Ref/Job No: 13GOSBUS-0034

8 May 2015

RE: Kembla Grange Waste Resource Recovery Facility, 50 Wylie Road, Kembla Grange (S14/0039)

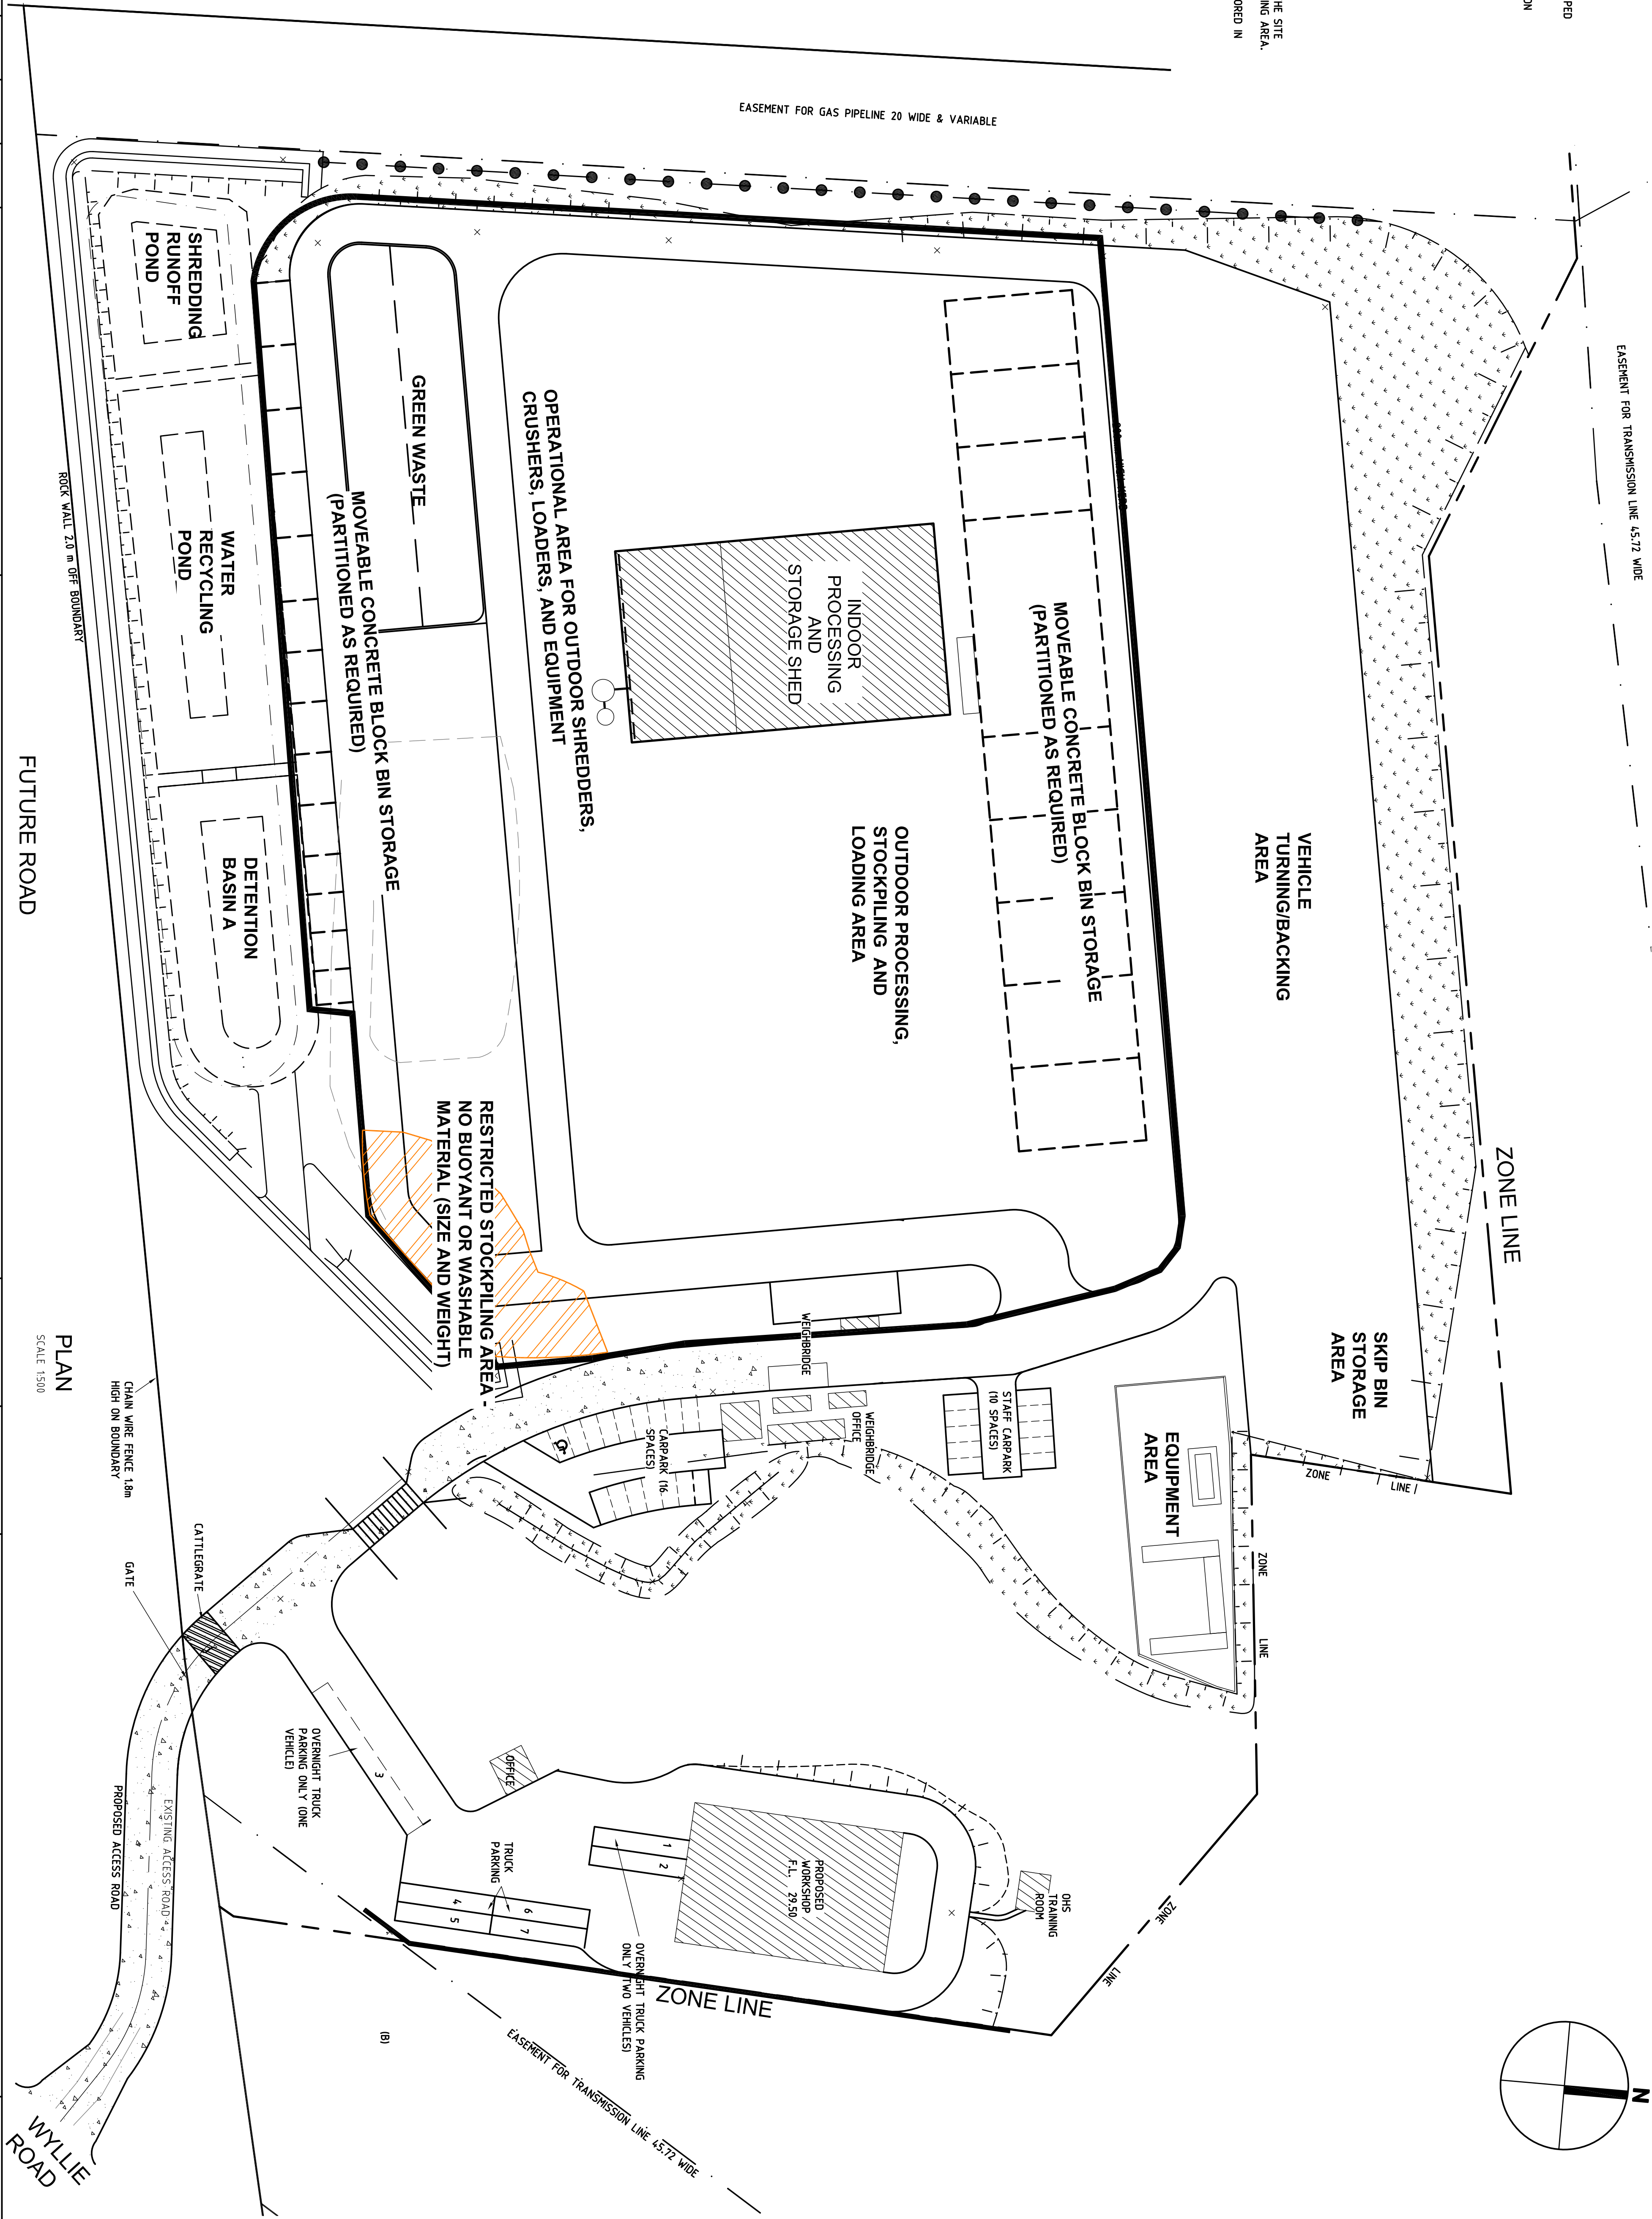
The recommended 100 m APZ is viewed to be excessive for the nature of the proposal and the level of bushfire risk to and from the site. Notwithstanding this, the site plan has been amended (Attachment 2) to confine the loading, stockpiling and processing stages of the combustible waste to more than 100 m from the riparian zone to the east as follows:

- Stockpiling and loading area for green waste and timber to be confined to the western and south-western sides of the 'Indoor Processing & Storage Shed' over 100 m from the riparian area, and
- 'Indoor Processing & Storage Shed' will house other combustible waste over 100 m from the riparian area.

It is requested that the RFS recommended condition be amended to require management as an Inner Protection Area to the facility area with the exception of the riparian zone.

Drawing Title PROPOSED INDUSTRIAL DEVELOPMENT LOT 10 DP 878167 WYLLIE ROAD, KEMBLA GRANGE SITE PLAN - USAGE AREAS		Project No. KF110816
Scale 1:500 @ A1 1:1000 @ A3		Drawing No. C29
Drawing Status ISSUED FOR DA APPROVAL		Sheet 13 Of 18
		Revision B

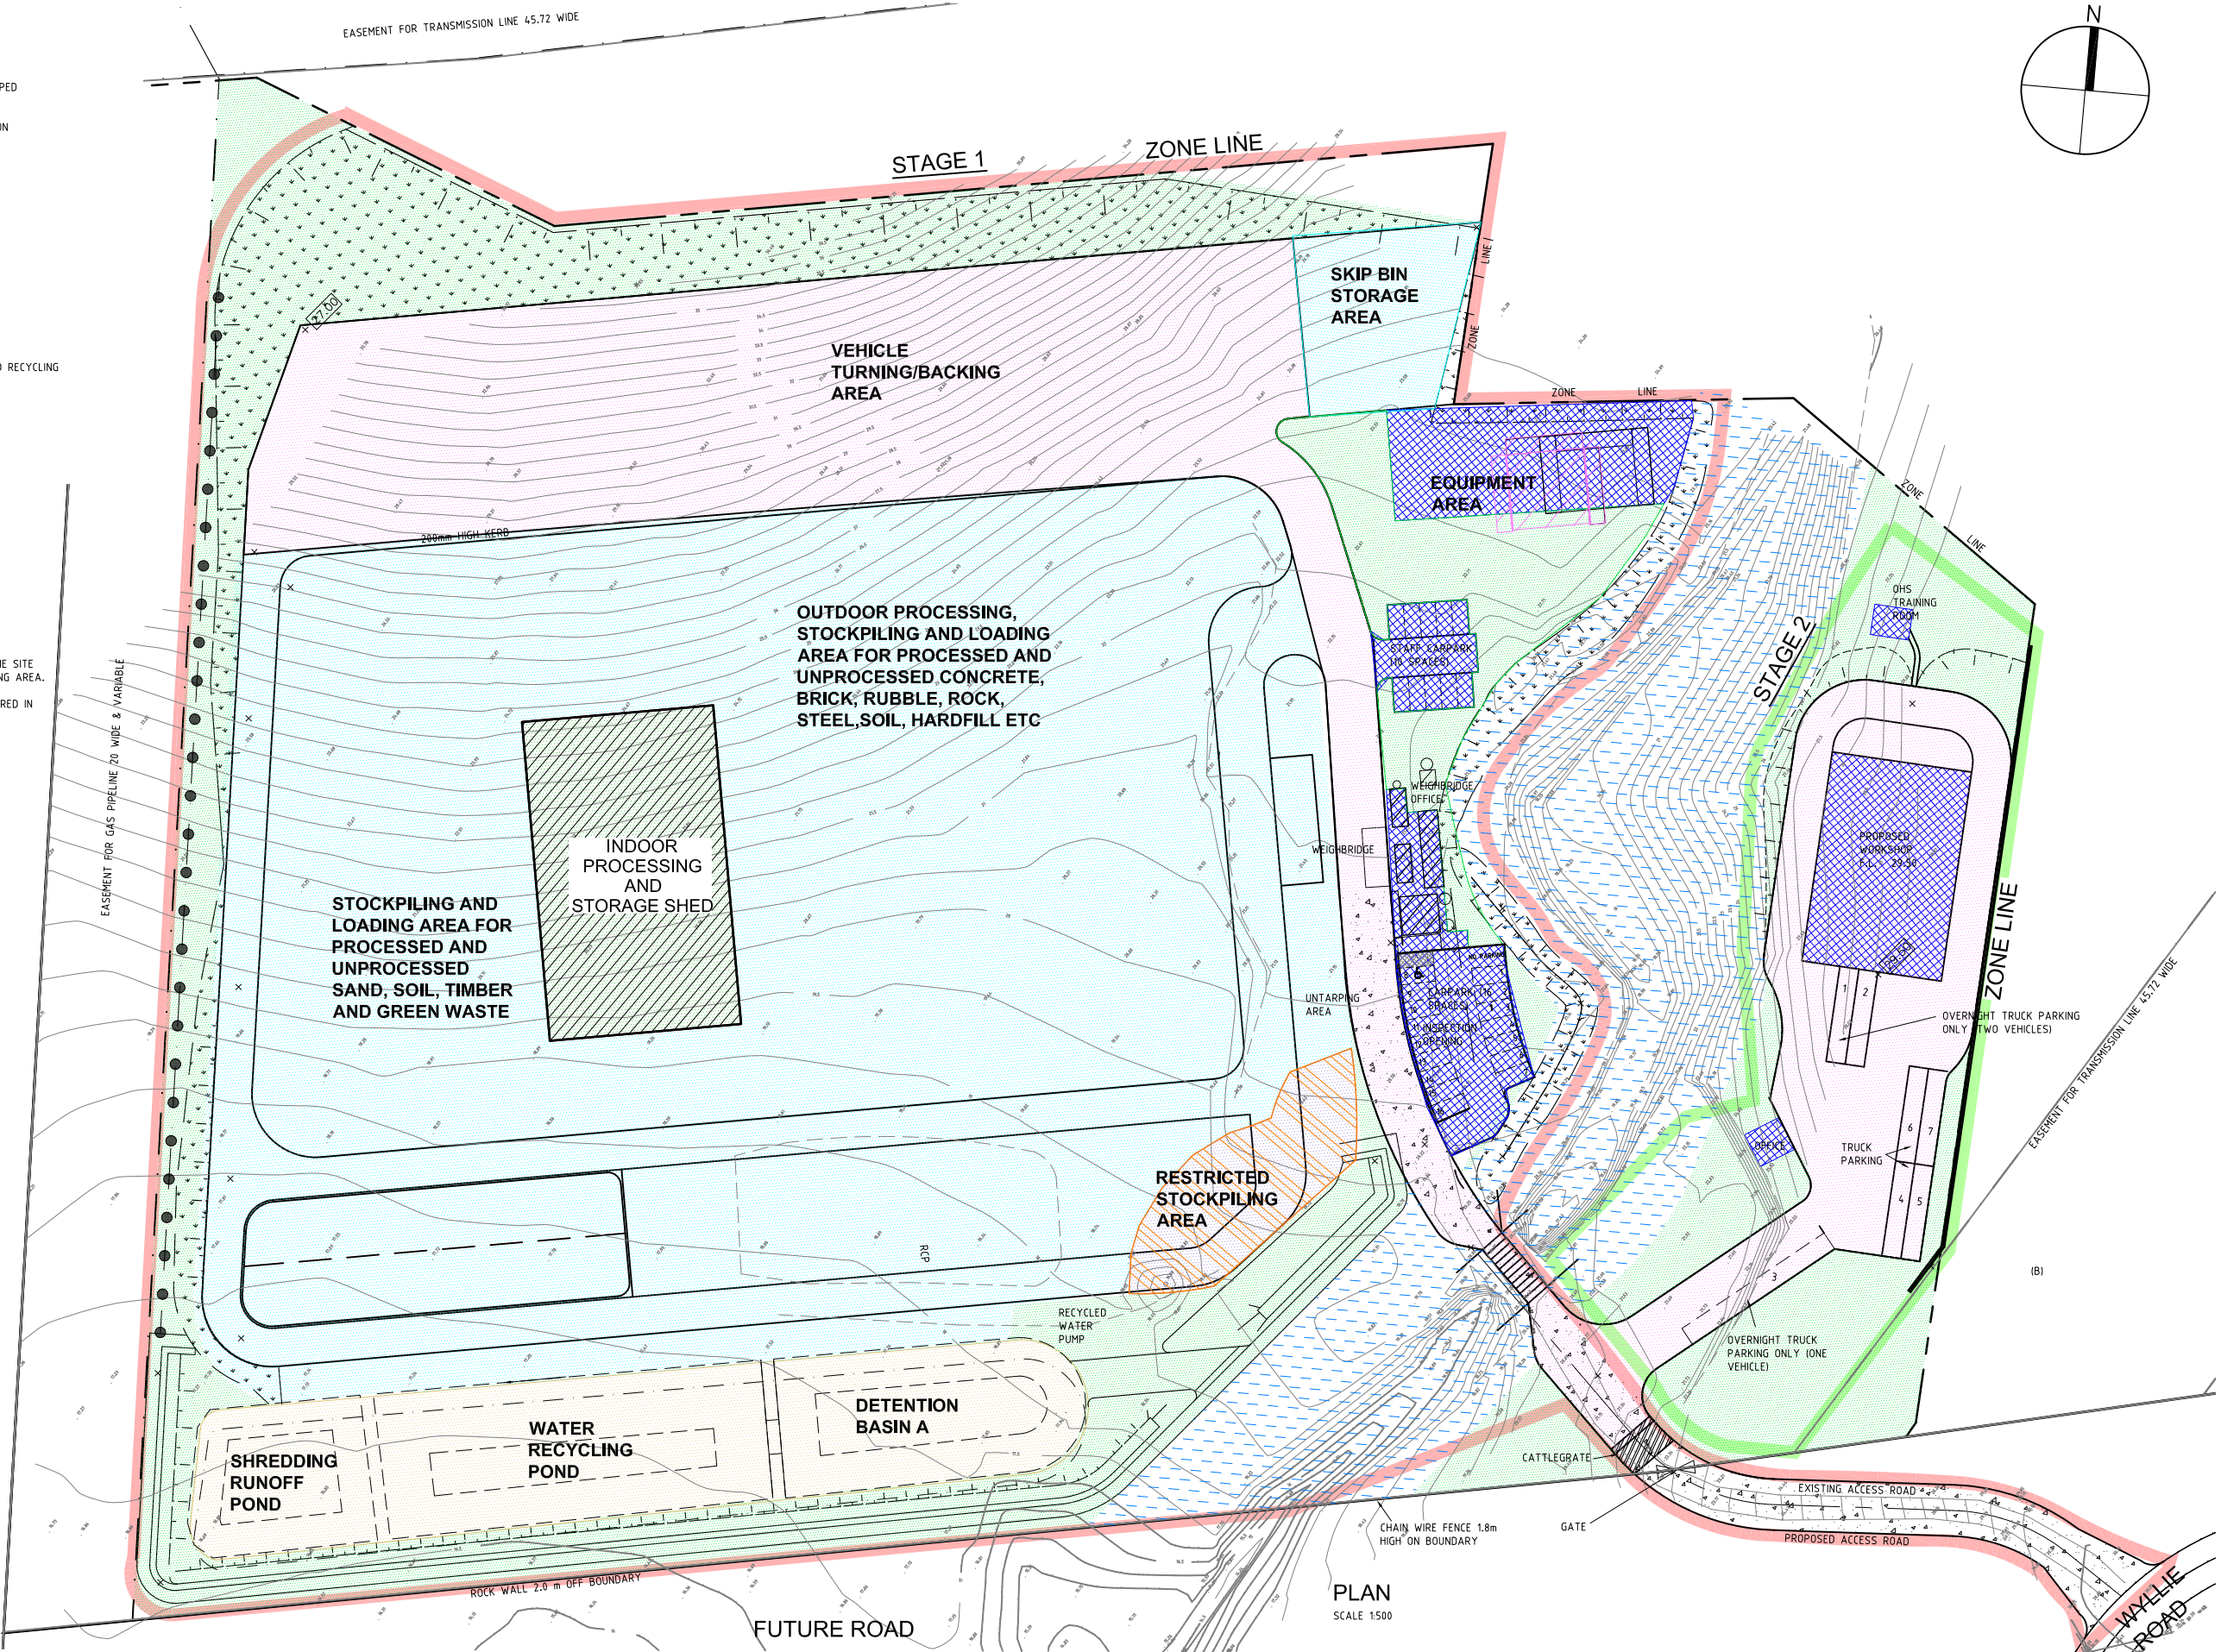
I order to confirm so, I would need a plan which reflects the general location of uses you mention below (i.e. revised / marked up Usage Areas Plan). Also, I would need something to come via DPE so that we could revise our response to them.

Requested plan attached. It clearly marks the location of storage/stockpiles – of which the combustible ones (greenwaste, timber and rubbish) are either in the shed or to the west of it, being 100m from the riparian zones to the east.
